Recommendation Report for Planning Permission for Works or Extension to a Dwelling

REF NO: Y/53/25/HH

LOCATION: Flints
Hoe Lane
Flansham
PO22 8NP

PROPOSAL: Part single, part two storey rear extension, dormer extension and alterations to fenestration.

Proposed North Elevation

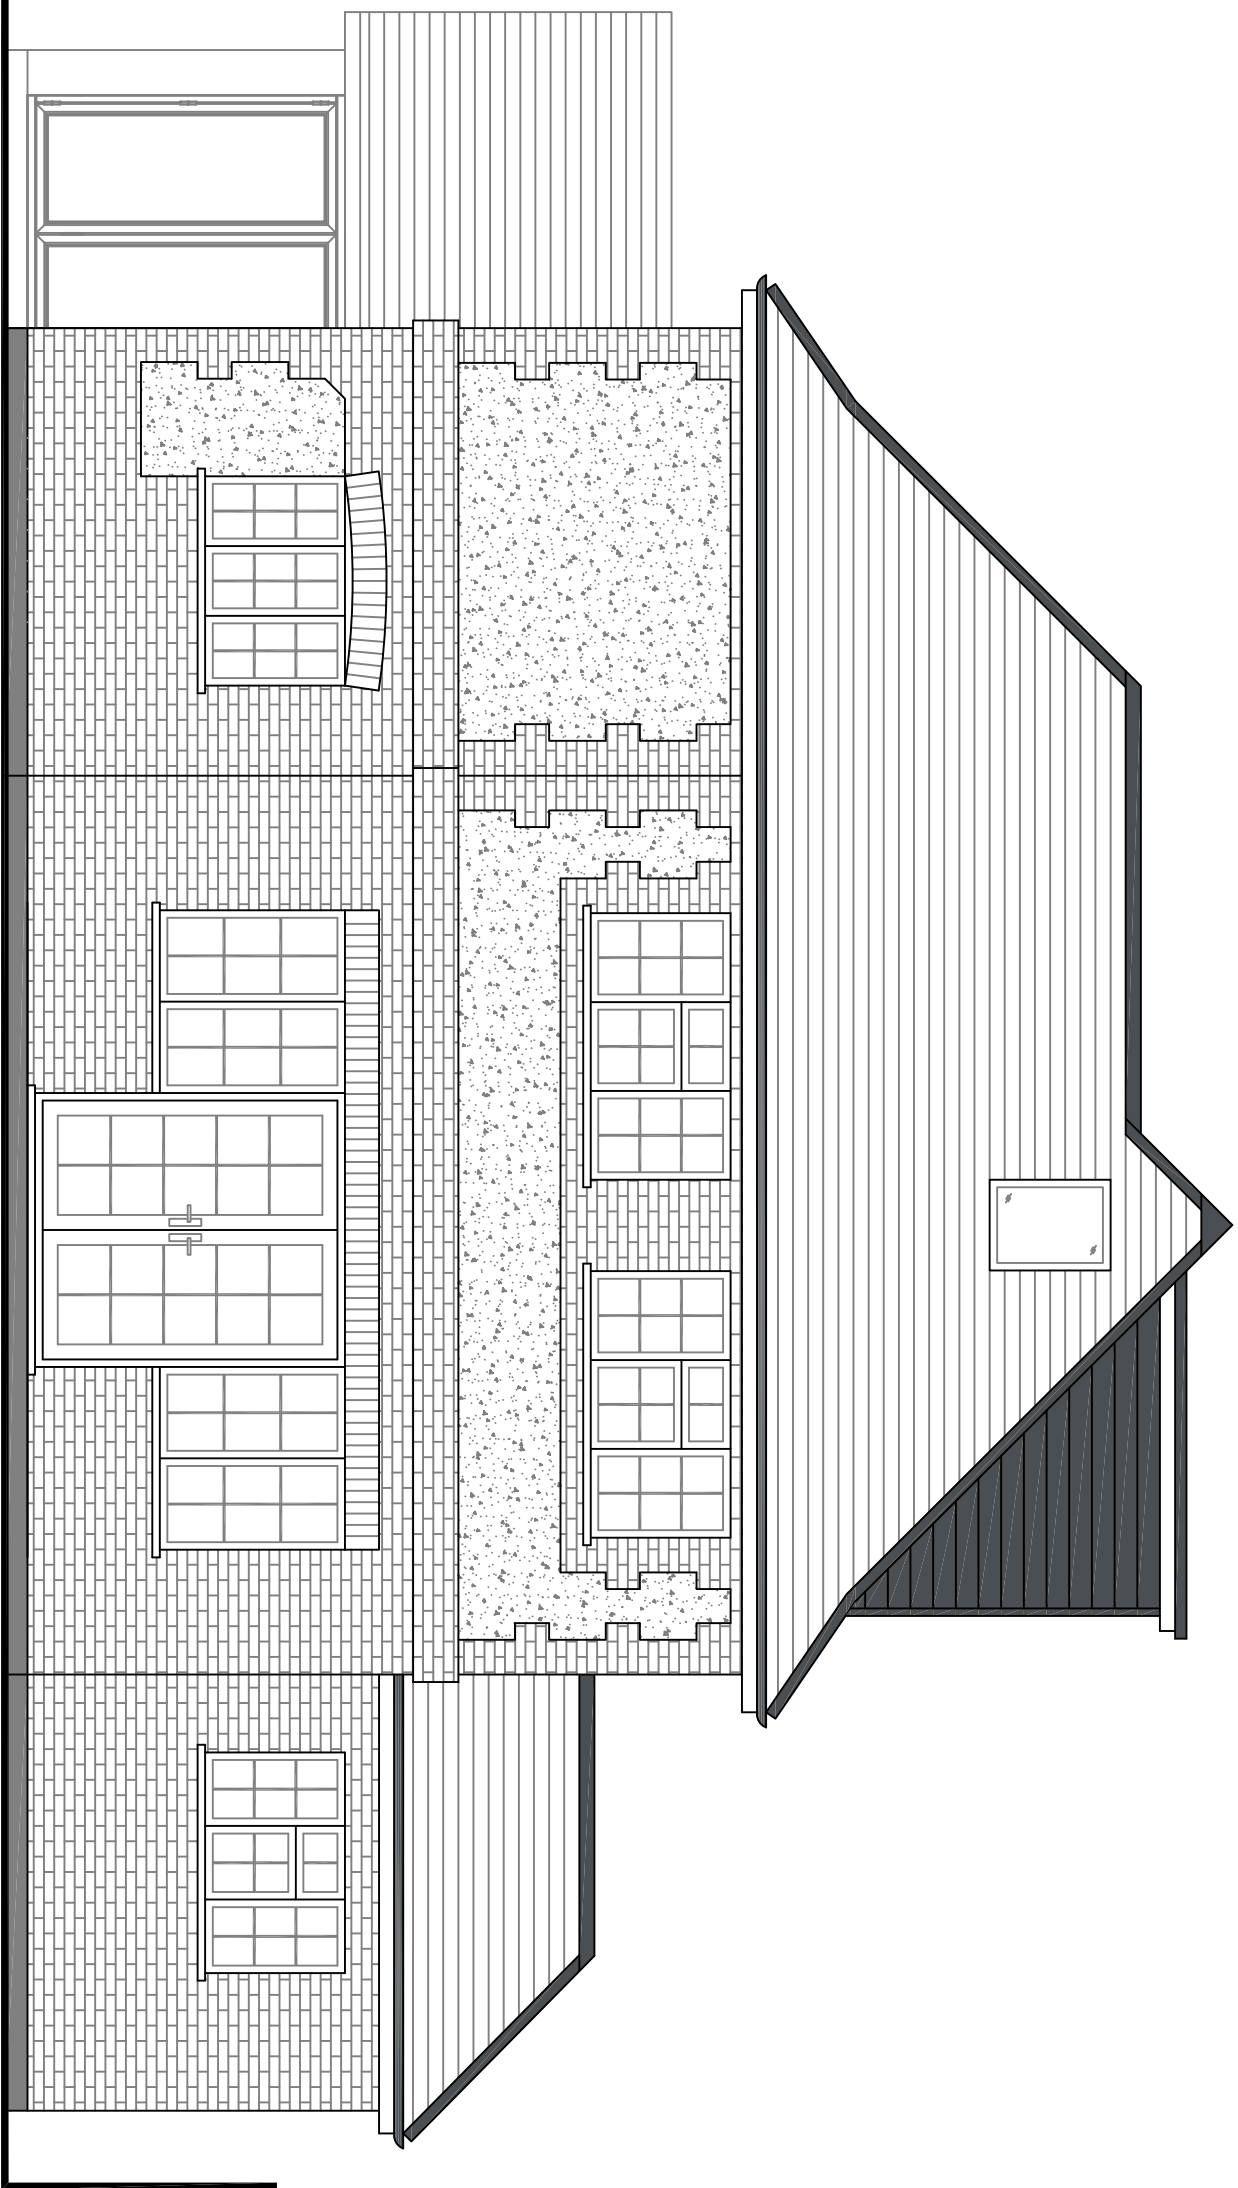
The proposed single storey extension would measure 5m in width, 4.7m in depth, with a maximum height of 4.4m and eaves height of 2.3m. It would feature a gable end with large windows. Whilst this extension would have a more modern appearance than the host dwelling, it is subservient and would not appear prominent within the street scene of Hoe Lane, reducing any harm to the character of the area.

The first floor extension would measure 4.7m in width, 3m in depth and would match the eaves height of the host dwelling. The first floor extension would increase the bulk and massing of the roof form, although it would not exceed the existing ridge height. The first floor extension would replace an existing catslide roof form, however the hipped roof form of the first floor extension would reflect the character and appearance of the host dwelling and the proposal would be of a size and scale that would be a subservient addition to the host dwelling. The proposed first floor extension would not result in harm to the visual amenity of the host dwelling, street scene or wider area.

The rear dormer would measure 5.7m in width and 2.1m in depth, with a flat roof with a height of 2.2m. There is an existing smaller dormer which the proposed would replace in a similar location on the west (rear) roof slope. Part M of the Arun Design Guide (ADG) requires dormers to be minor incidents in the roof plane and centrally located as to not damage the original character and appearance of the building and its surrounding area, incorporating pitched roof in most cases. While the proposed rear dormer features a flat roof design, it is sited to the rear and would not be visible from the street scene. The dormer would be set in from the flank elevations, set up from the eaves and set down from the ridge height and would not result in harm to the visual amenity of the host dwelling.

The single storey extension is sited approximately 13m from the boundary with the north (side) neighbour, Bonhams. There are large scale windows proposed to the east and north elevations, but as these windows would have an outlook of the rear garden, the proposed extension would not result in increased overlooking impacts. As a result of its scale and siting, this element would not result in any overbearing, overshadowing, or overlooking, and would not result in harm to residential amenity. 2 No. rooflights are proposed within the south (side) roof slope. There are 3 No. existing rooflights within the main roof. The rooflights accord with Part M of the Arun Design Guide as they maintain the privacy of the neighbouring properties and are used discreetly.

The first floor extension would be sited approximately 6m from the boundary with the north (side) neighbour, Bonhams. Given the siting and scale of the proposed extension, this element would not result in any overshadowing or overbearing impacts to neighbouring properties. Fenestration is proposed within the eastern elevation of the extension at ground and first floor levels. The outlook from this fenestration would not be dissimilar to the views available from the existing ground and first floor level fenestration within the eastern elevation, and the proposal would not result in additional overlooking or loss of privacy.

The rear dormer would be sited approximately 35m from the closest elevation of the neighbour to the rear, Jem House, and would not result in harmful overlooking impacts due to this distance and the existing boundary treatment and mature vegetative screening. As the dormer would be contained within the existing roof slope and would be sited a significant distance from neighbouring properties, the dormer would not result in any overbearing or overshadowing impacts.

There are proposed alterations to fenestration including a set of patio doors within the north elevation, serving the rear garden of the host dwelling. 1 No. window is removed from the south elevation and 2 No. windows are introduced within the east elevation. Both would serve the rear garden and would not result in increased overlooking impacts.
